From [REDACTED]
Sent: 15 July 2021 16:04
To: [REDACTED]
Cc: ENC PLANNING <PLANNING.ENC@northnorthants.gov.uk>
Subject: FW: Planning Application NE/21/01069/FUL

REF NE/21/01069/FUL Single storey ancillary accommodation to replace existing single garage at Pond Yard 32, Back Lane, Collyweston, Northamptonshire, PE9 3PJ

**PROPOSED**  
Location & Block Plan

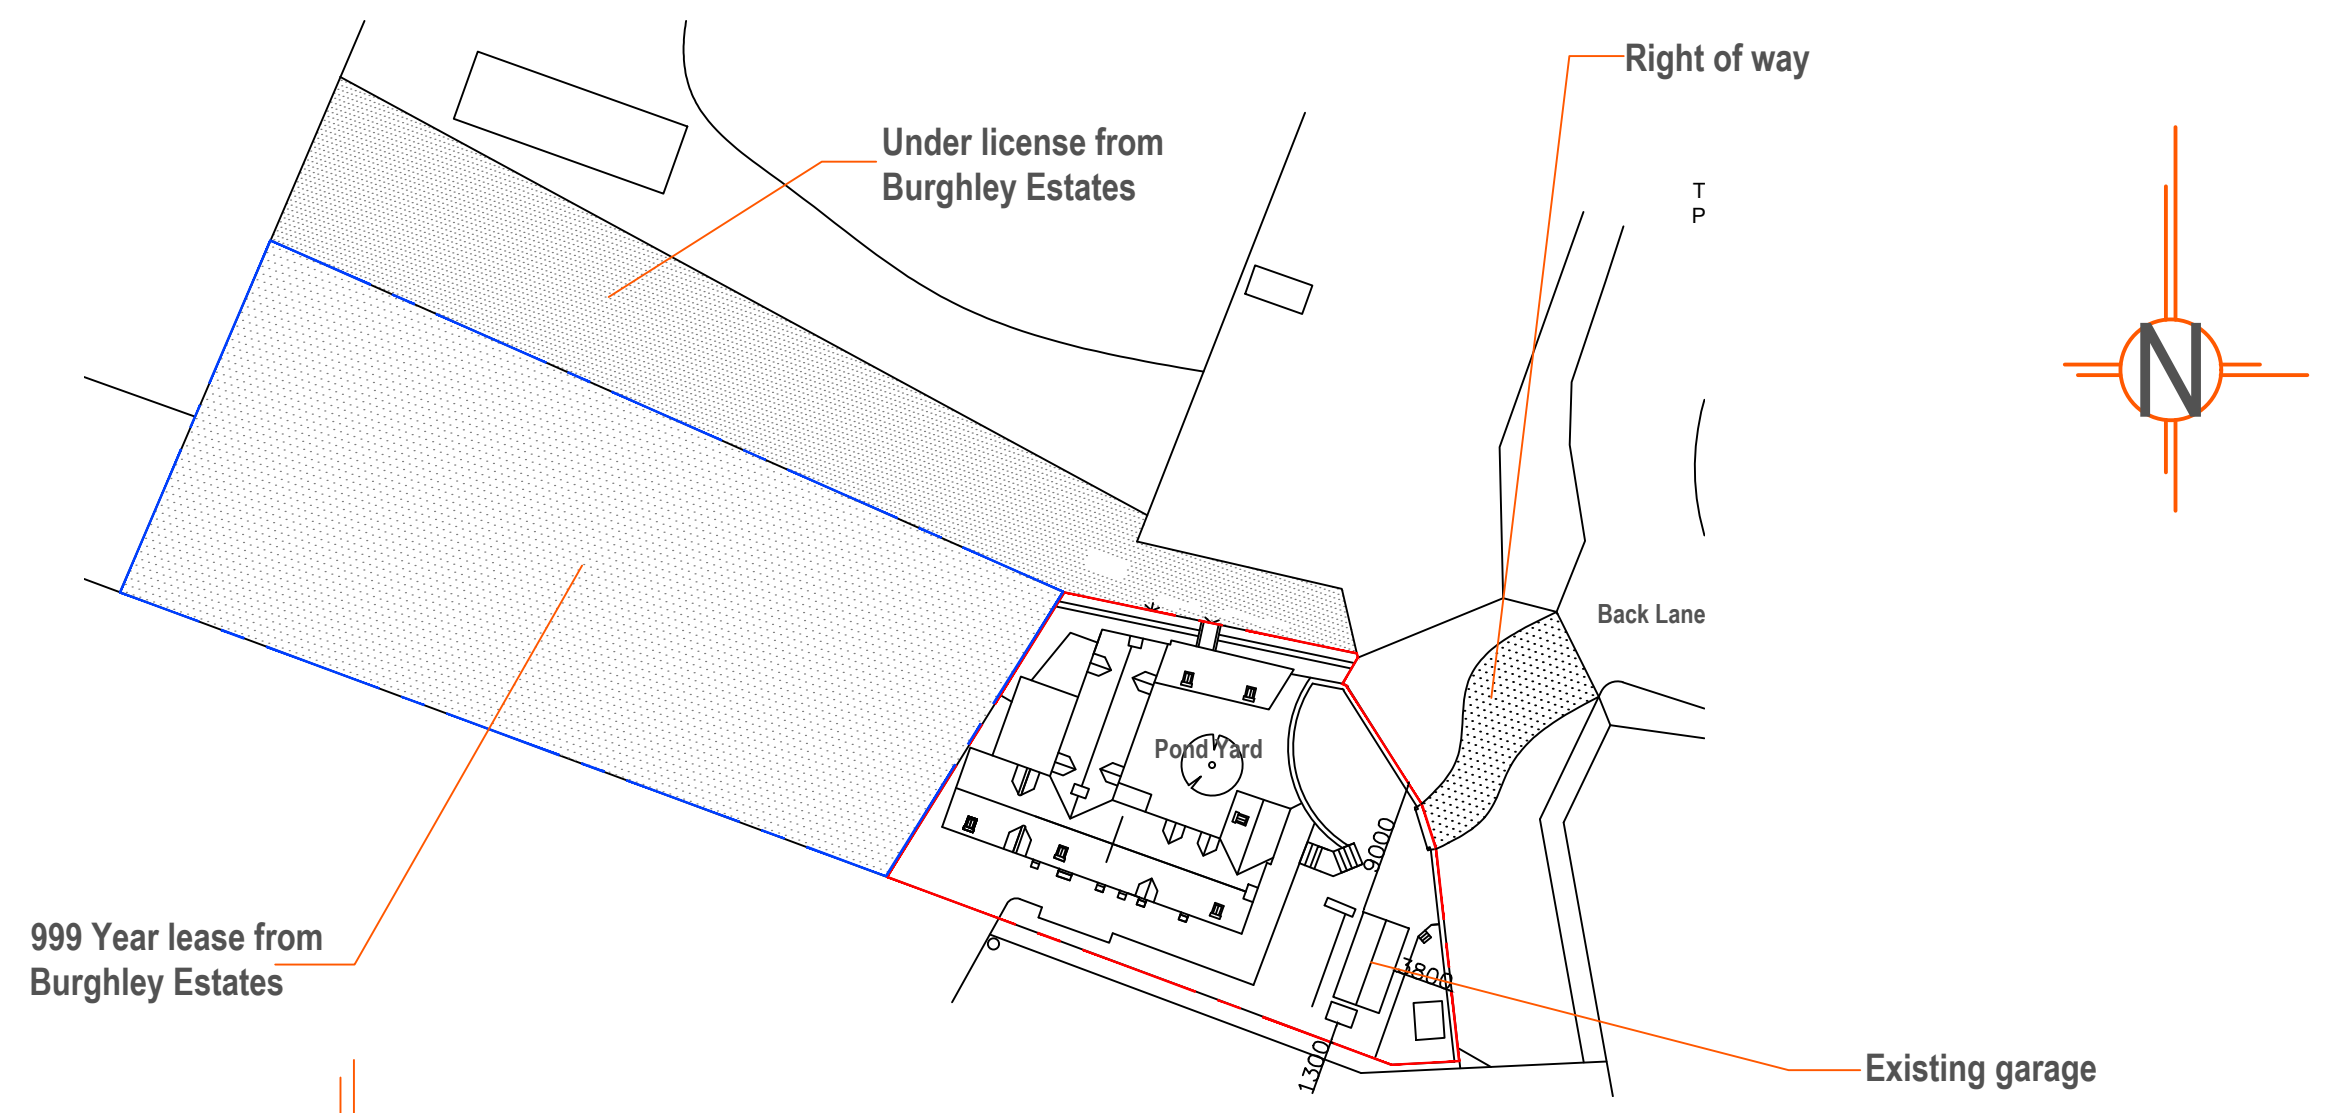
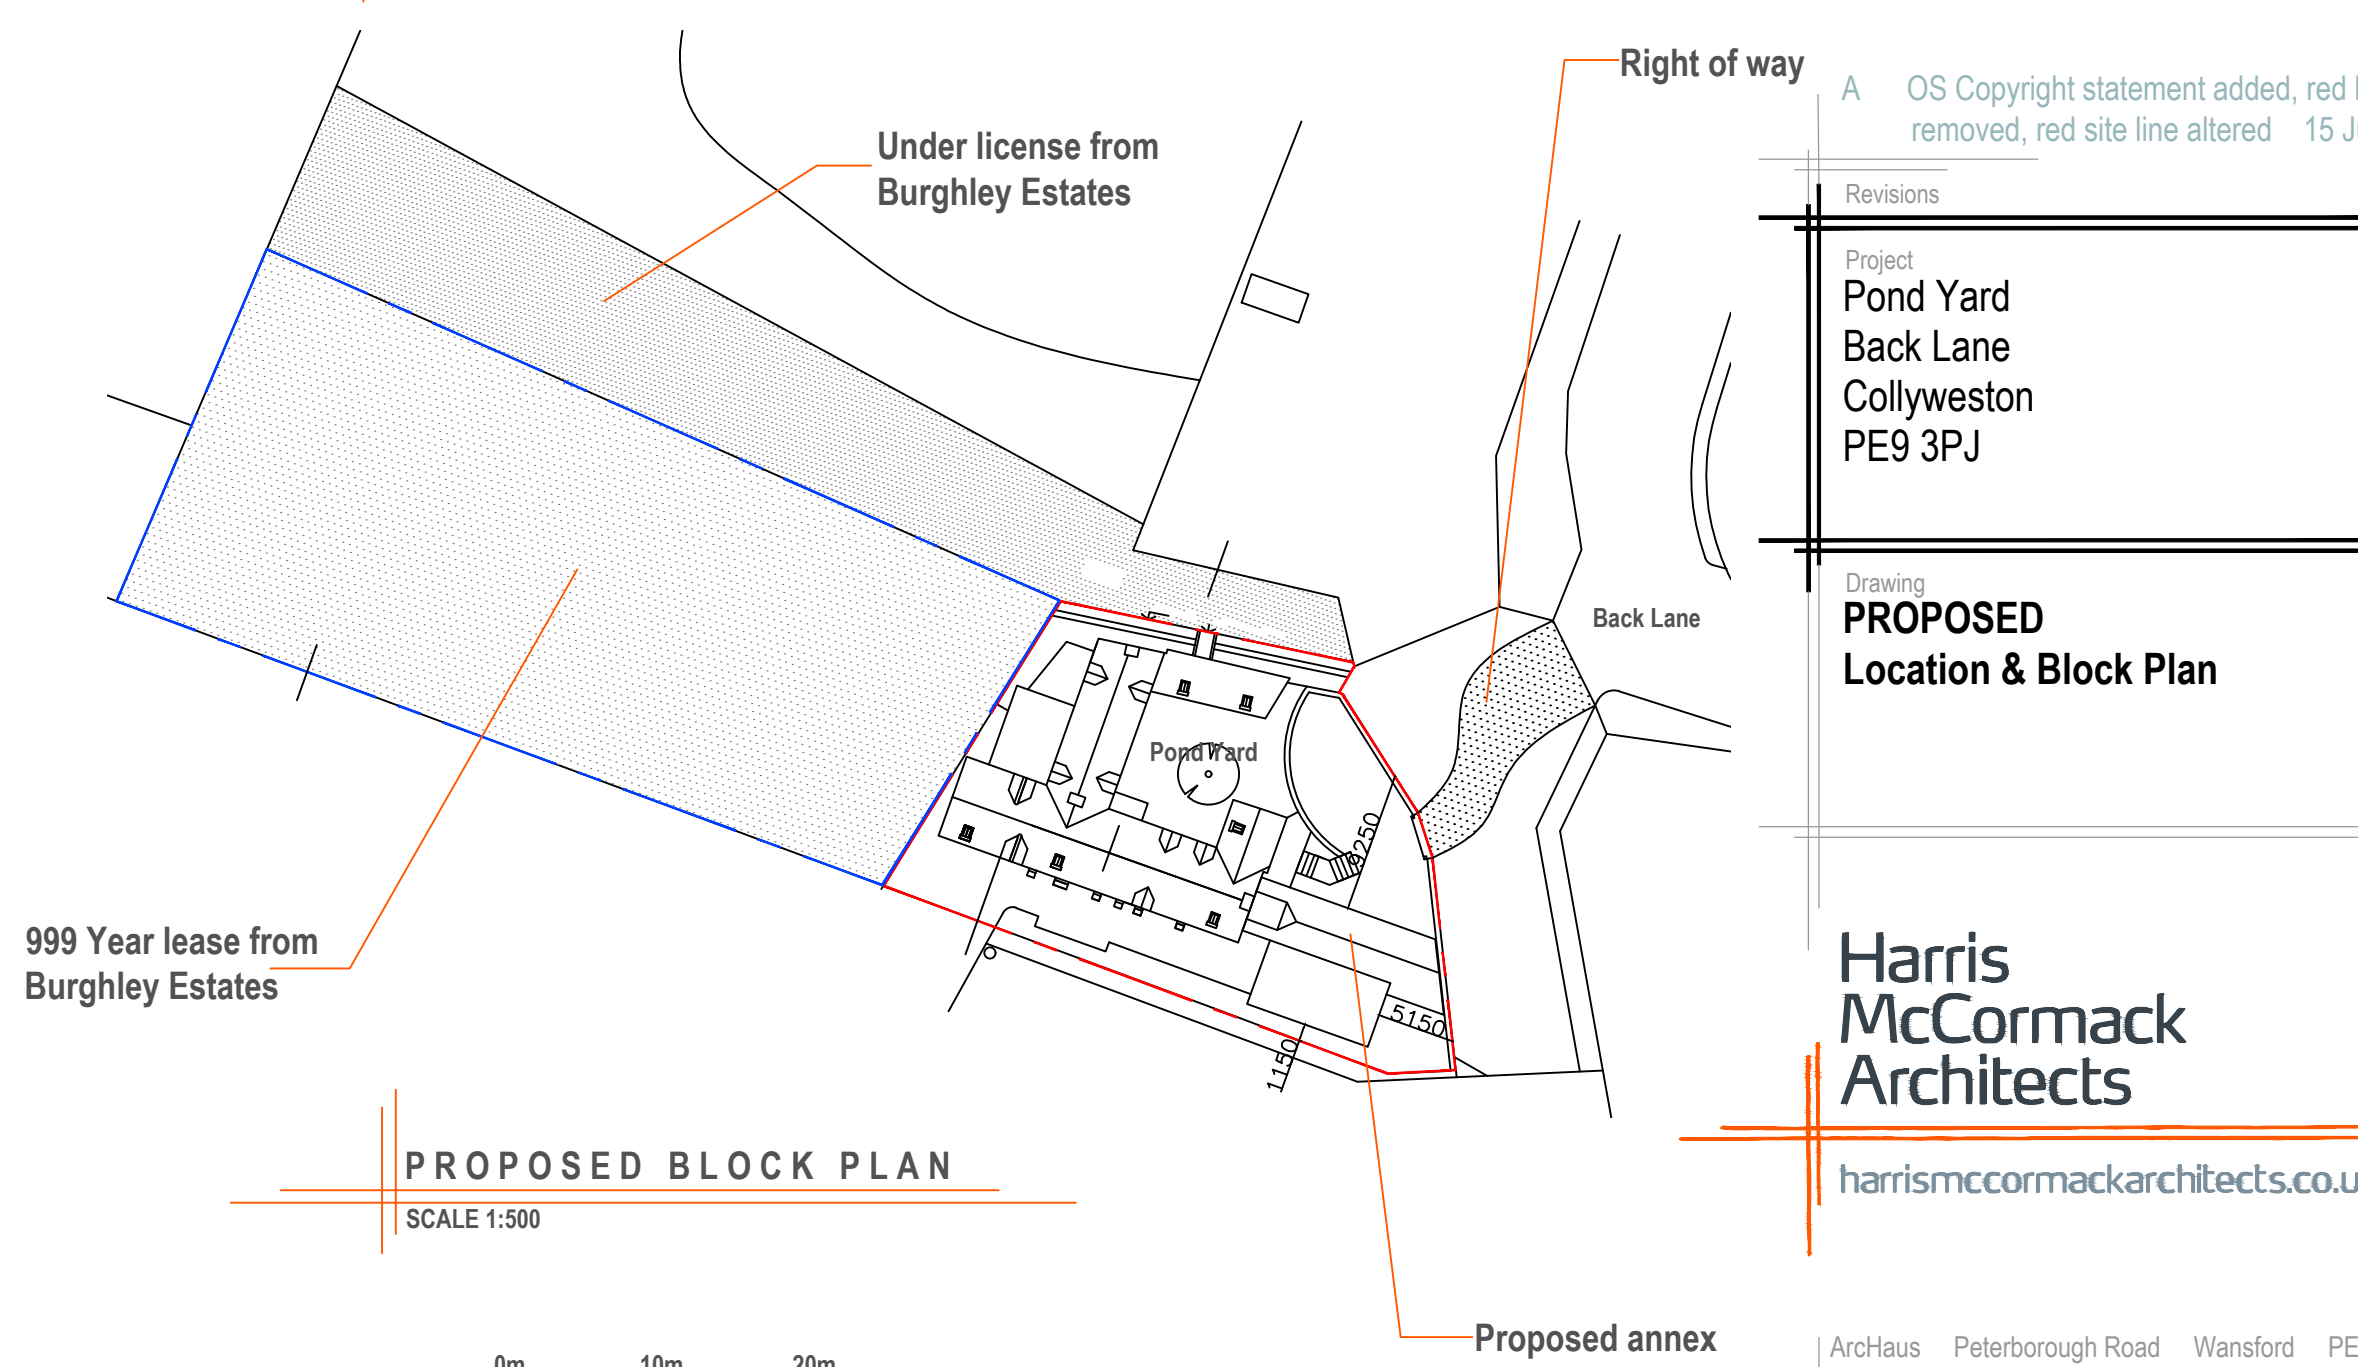
Secondly, I note that the location plan contains red lines (possibly roads?) that do not relate to the application site – these will need to be shown in a different colour, additionally the red line edging the site appears to be open in a couple of places, this red line needs to be a solid red line and also include the land required for access to the adopted highway. Also, as it appears that Ordnance Survey map data has been used in the submitted location a copyright statement on the drawing e.g. 'Contains Ordnance Survey data © Crown copyright [and database right] 2015' must be provided. Please provide an amended location plan.
